ADDENDUM TO NOBLE DENTON MARINE SERVICES REPORT TO SPIRIT ENERGY REPORT REVIEW OF MARINE HAZARDS (DECEMBER 2018)

TECHNICAL NOTE

Date:	14 th December 2018	Ref:	TN – 777	Rev: 0
Project No:	10074959 Task 60	Client:	Spirit Energy	
Attn:	Max Rowe			
Author:	Robert Sinclair	Checked:	Sujit Viswanathan	
Subject:	Addendum to Report A 13423 Rev 3 – Review of Marine Hazards – Hornsea 3 Windfarm

Figure 4.3: J6A platform REWS detection threshold over the Hornsea Three array area (342 turbines).

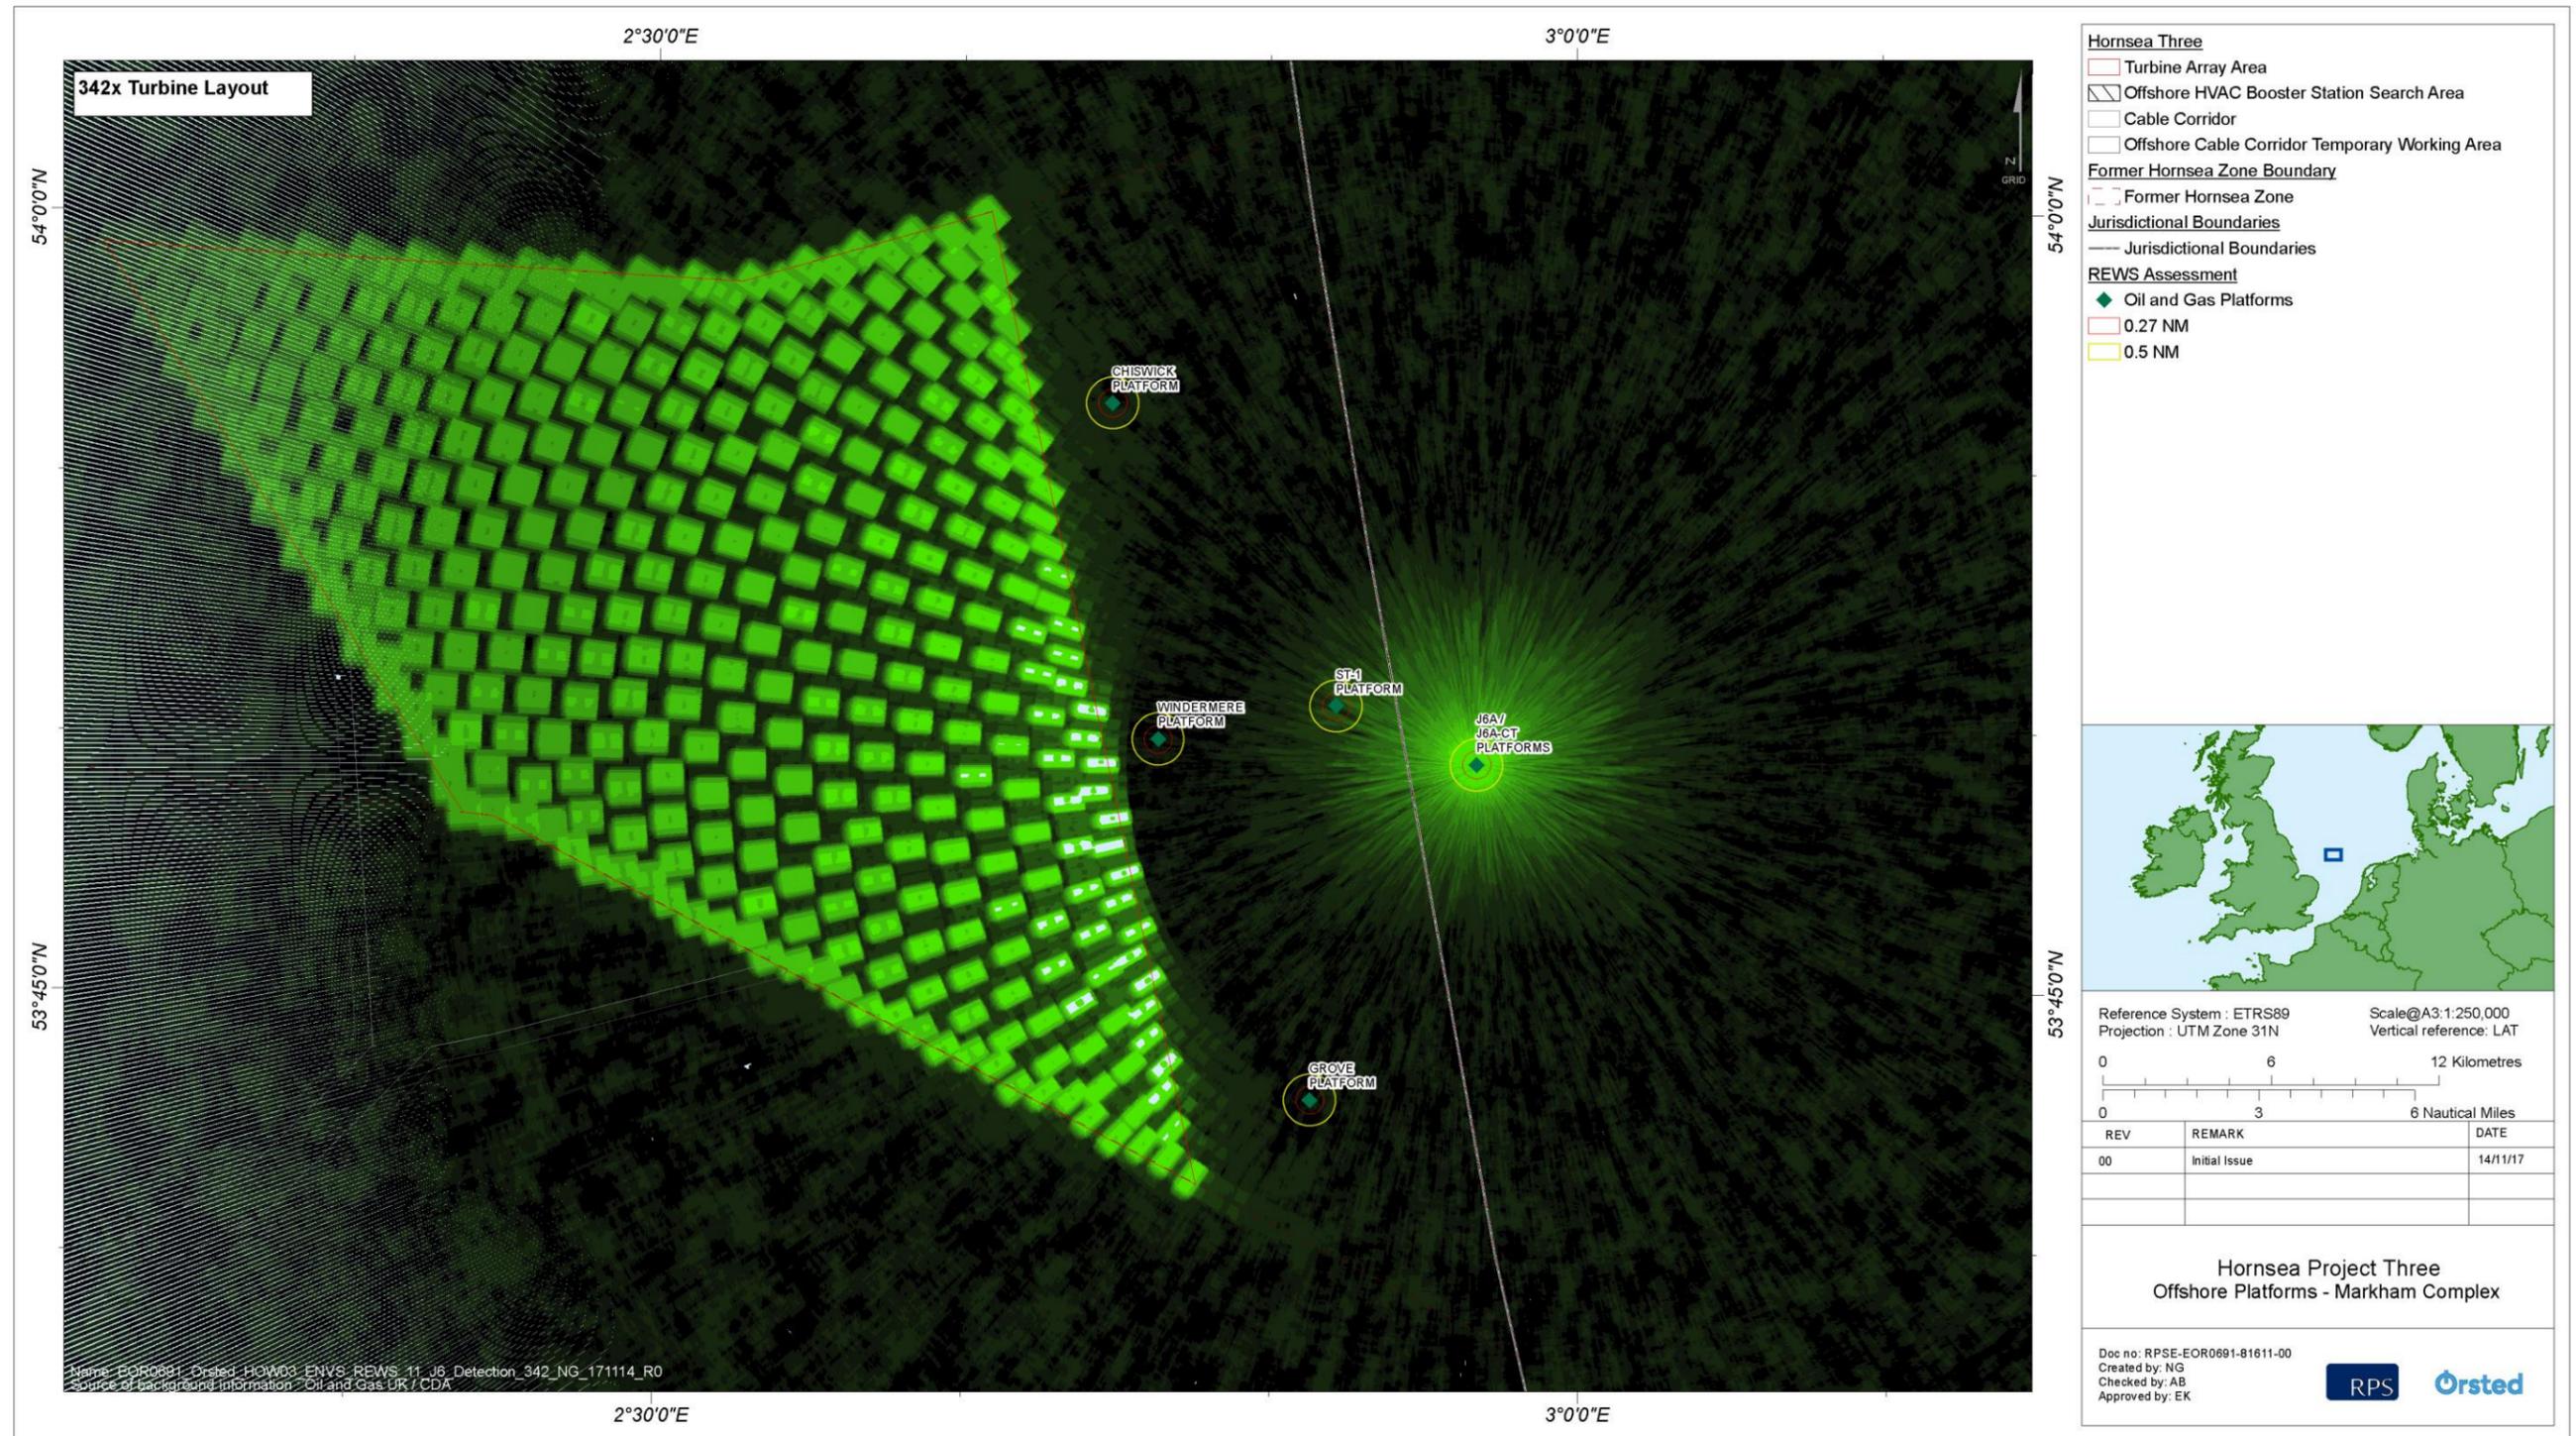
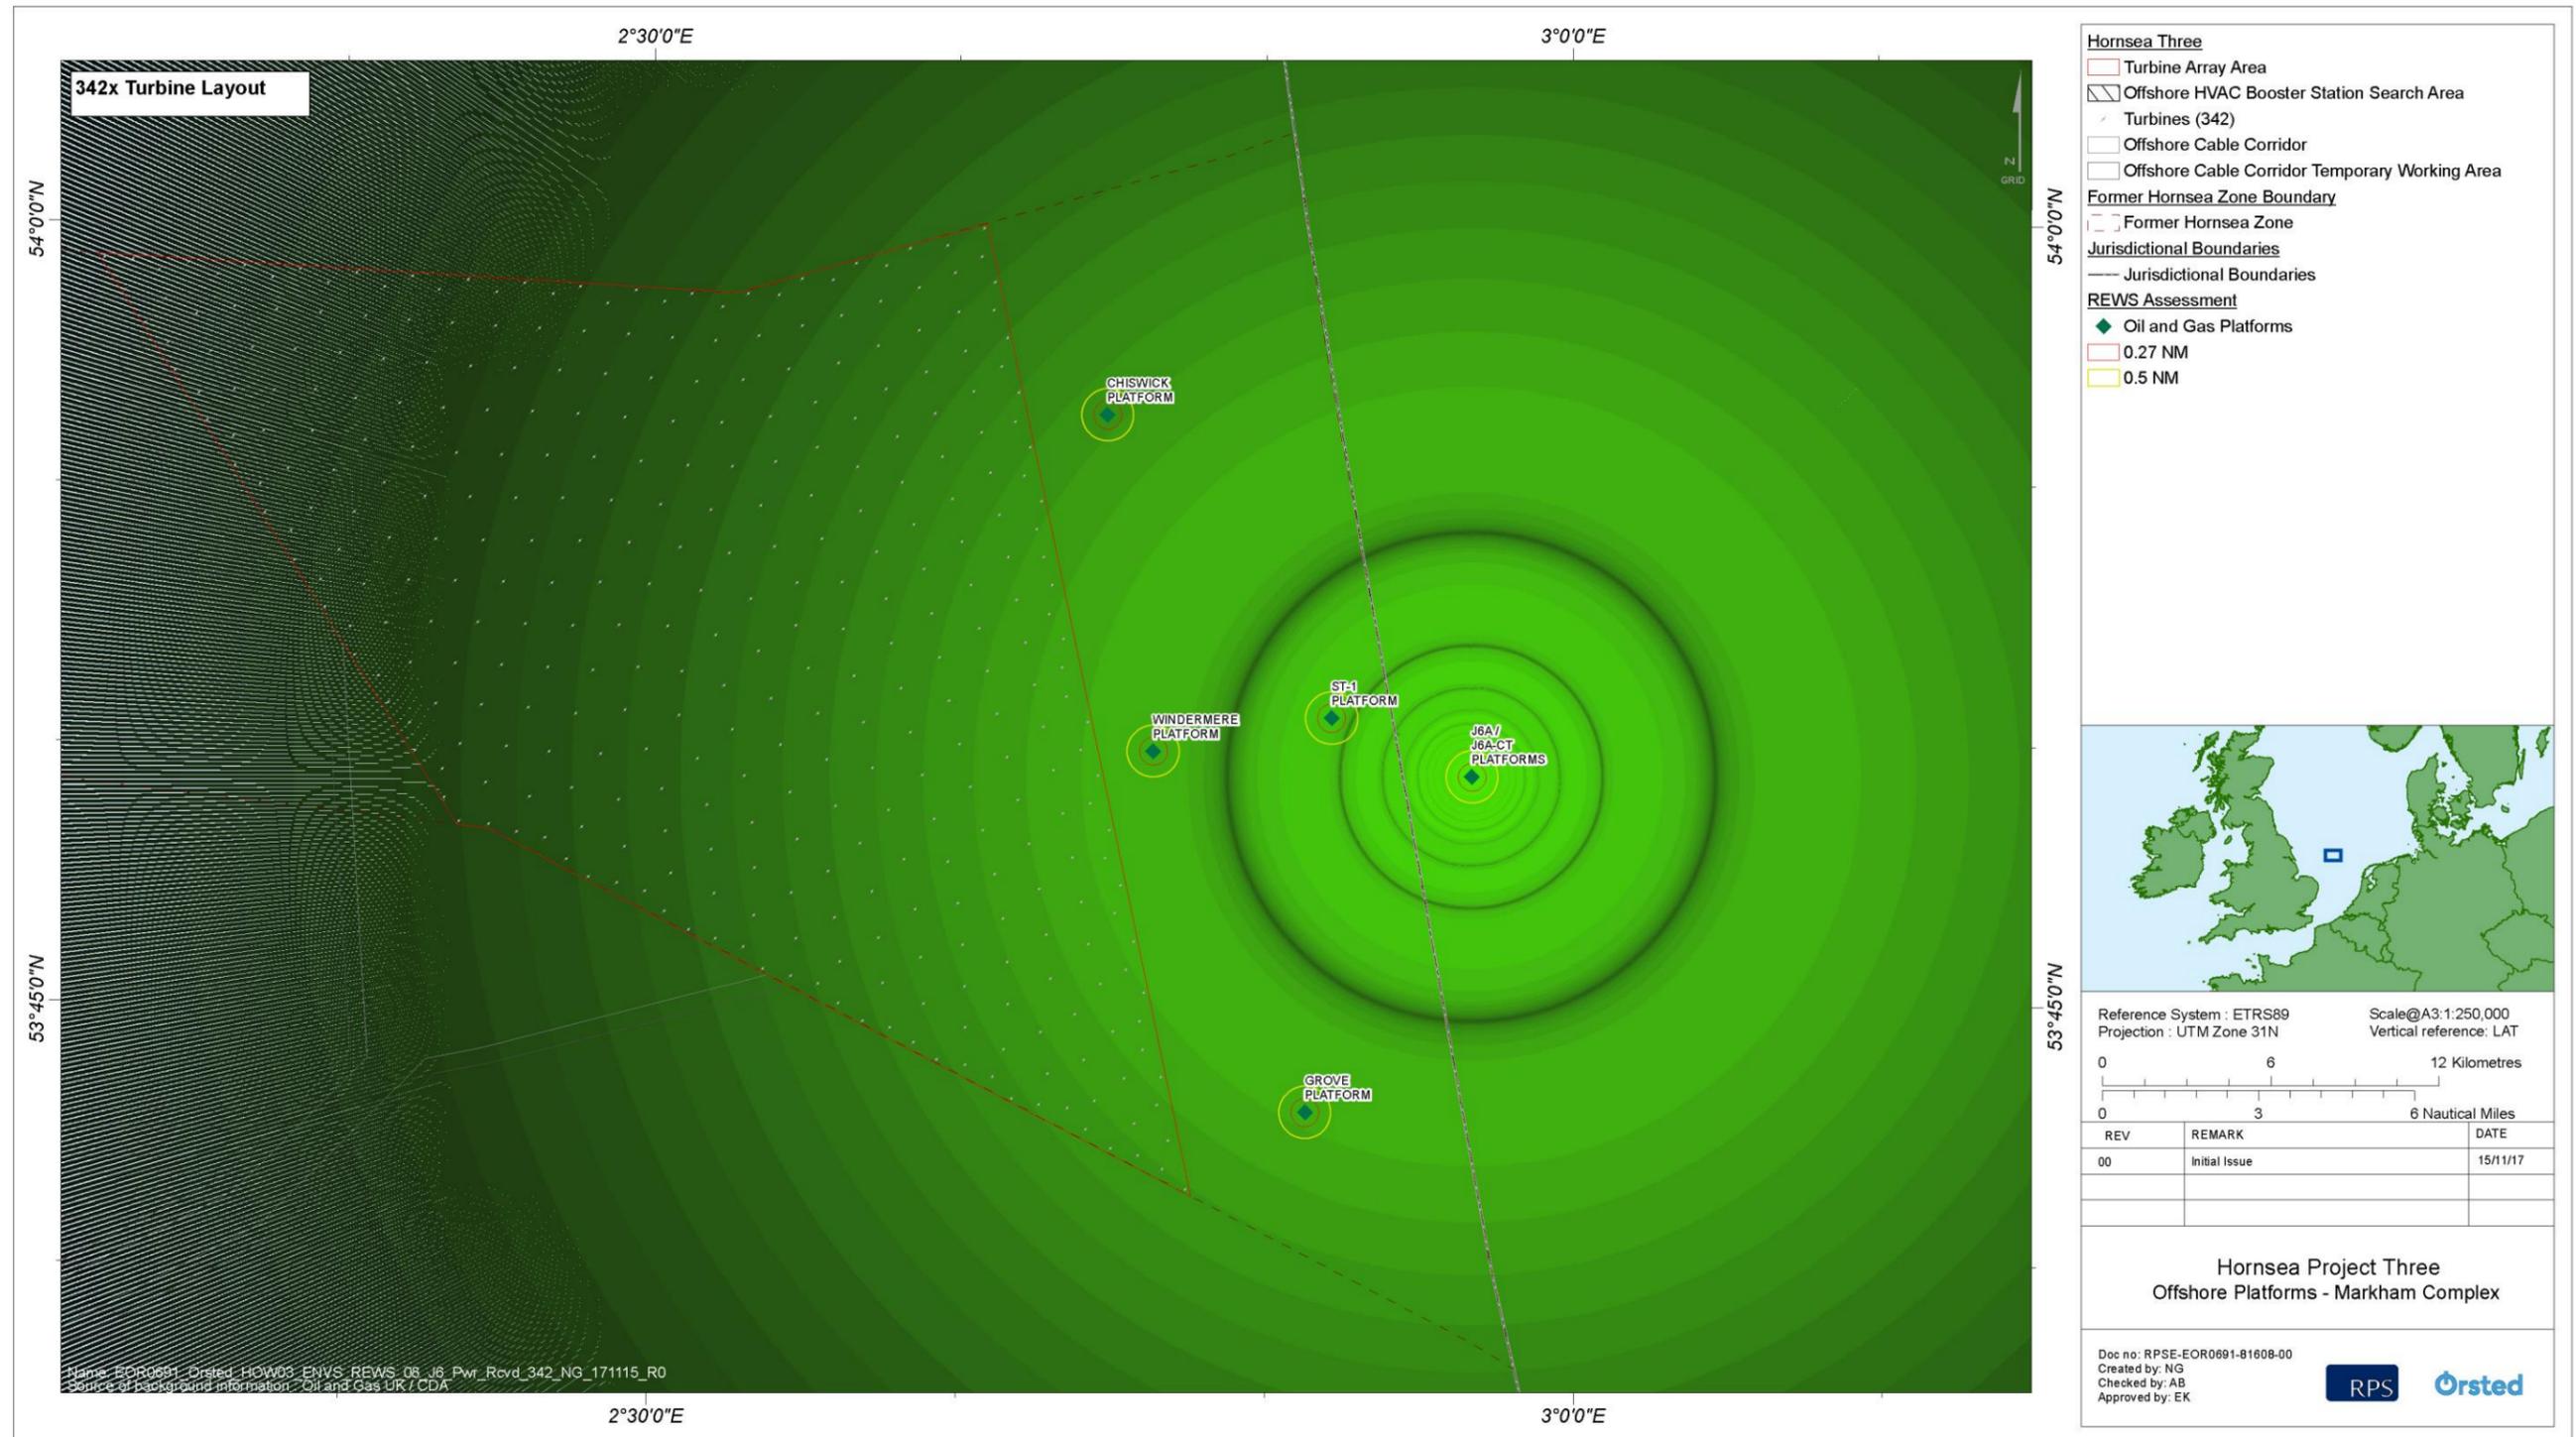
We also note that recent correspondence between Spirit Energy and Ørsted indicate Ørsted's belief that platform J6A has a RACON and AIS that would not be affected by the turbines in the array. Whilst we generally agree with this assessment in relation to the RACON and AIS, platform J6A also has, but as its primary means of detecting approaching and errant vessels (towards itself and its satellite platforms of Grove and Chiswick NUIs), an ARPA (Automatic Radar Plotting Aid) system which we believe will highly likely be affected in its practical operation by the planned array. We can also confirm that, in fact, J6A does not have a REWS system as outlined in the Applicant's documentation. There is, therefore, a further gap in the Applicant's risk assessment and this too is a real concern for safe vessel movement close to the Spirit Energy offshore infrastructure.
